From: Iqraa Malik [REDACTED] > on behalf of Terraquest
[REDACTED] >
Sent: 20 August 2026 08:16
To: Iqraa Malik
Subject: FW: Request for further information AW/152/26/HH
Attachments: 3 Meadow Way Aldwick Biodiversity enhanced statement.pdf; Existing and Proposed Roof Plans revised.pdf; Proposed Floor Plans revised.pdf; Proposed Roof Joists Plan revised.pdf

From: Farhad Aarabi [REDACTED] >
Sent: 17 August 2026 10:45
To: Planning.Responses <[REDACTED]>
Subject: Re: Request for further information AW/152/26/HH

PROJECT		Proposed single storey rear extension & new pitched roof dormer 3 Meadow Way Bognor Regis Aldwick w.Sussex PO21 4HG	
TITLE		Existing and Proposed Roof Plans	
CLIENT		Mr Alan Chiverton	
SCALE	1: 100 at A3 paper size	DATE	29/07/2026
DRAWING NO.	1280-03	rev.	17/08/2026

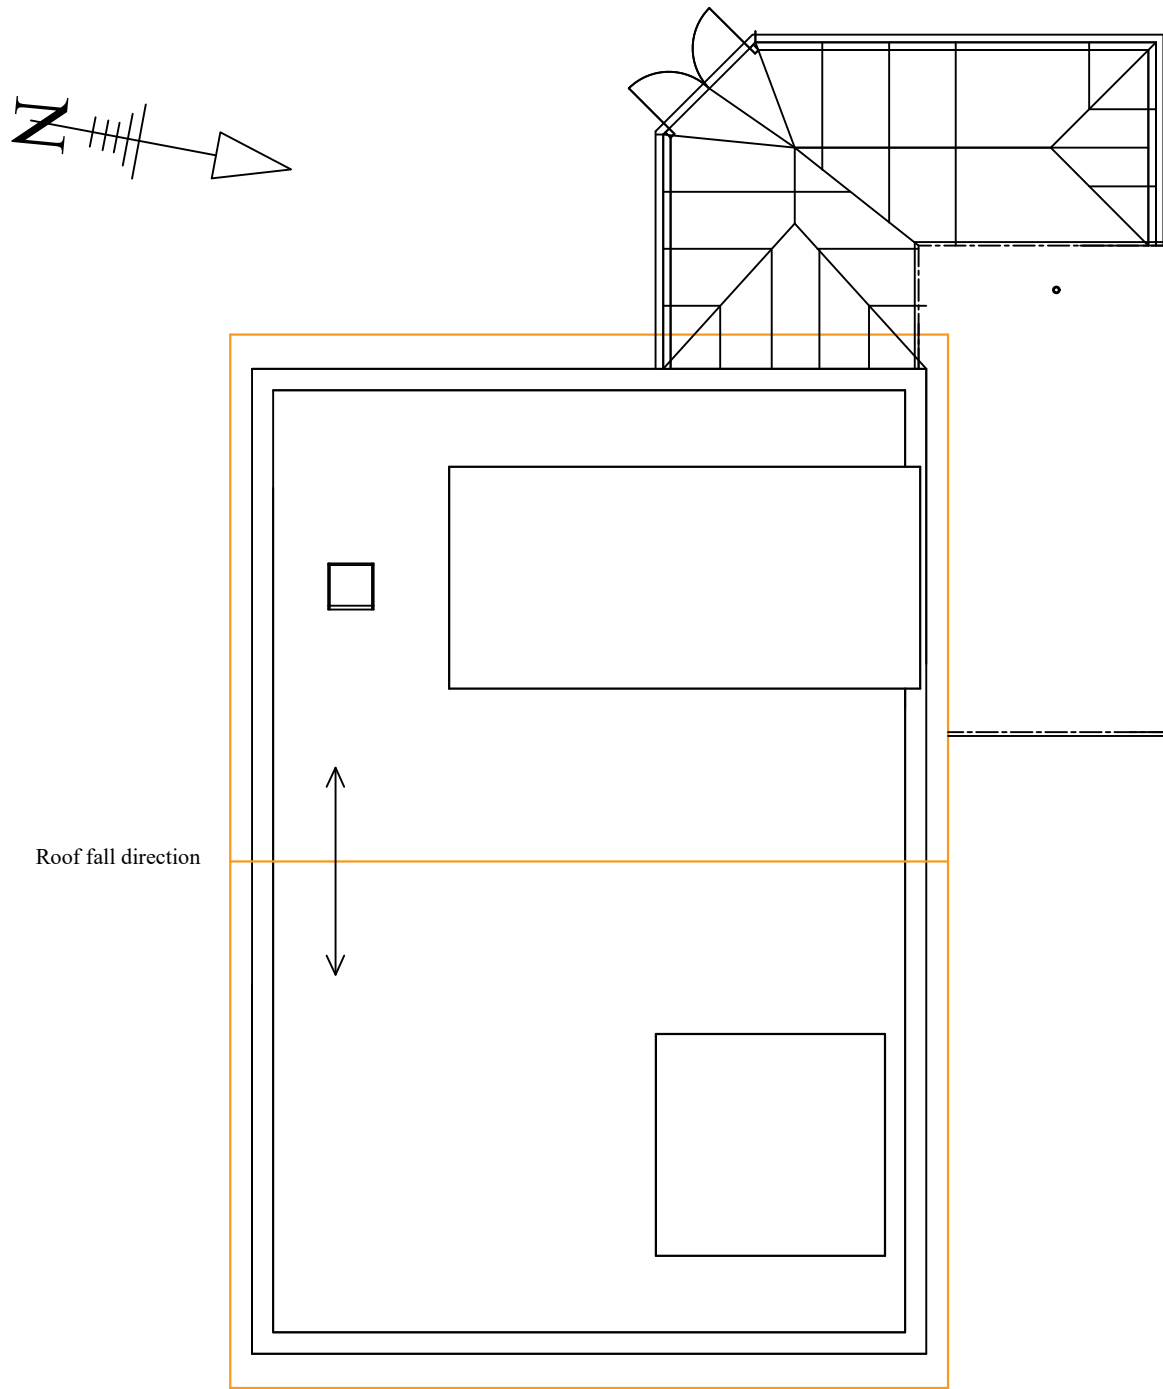
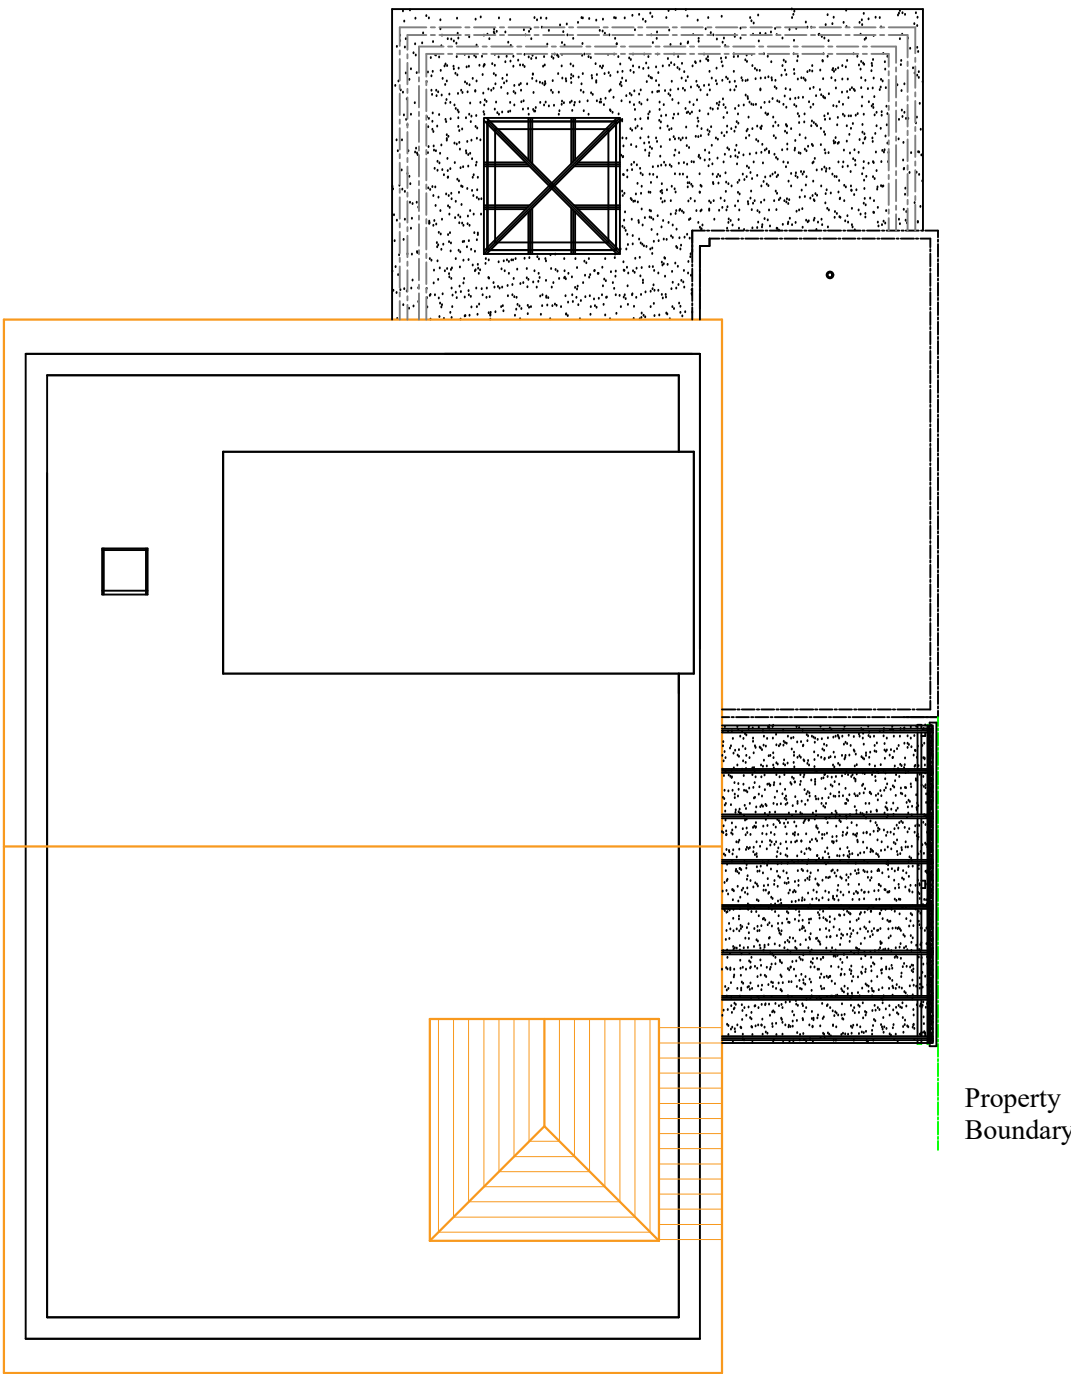
Many thanks for your email. Please find attached files, amended plans as requested. The new canopy will be 170.5mm from the outer edge of the post to the boundary and no part of the canopy will be over the boundary. I hope this is to your satisfaction and be glad to assist if further information is required.
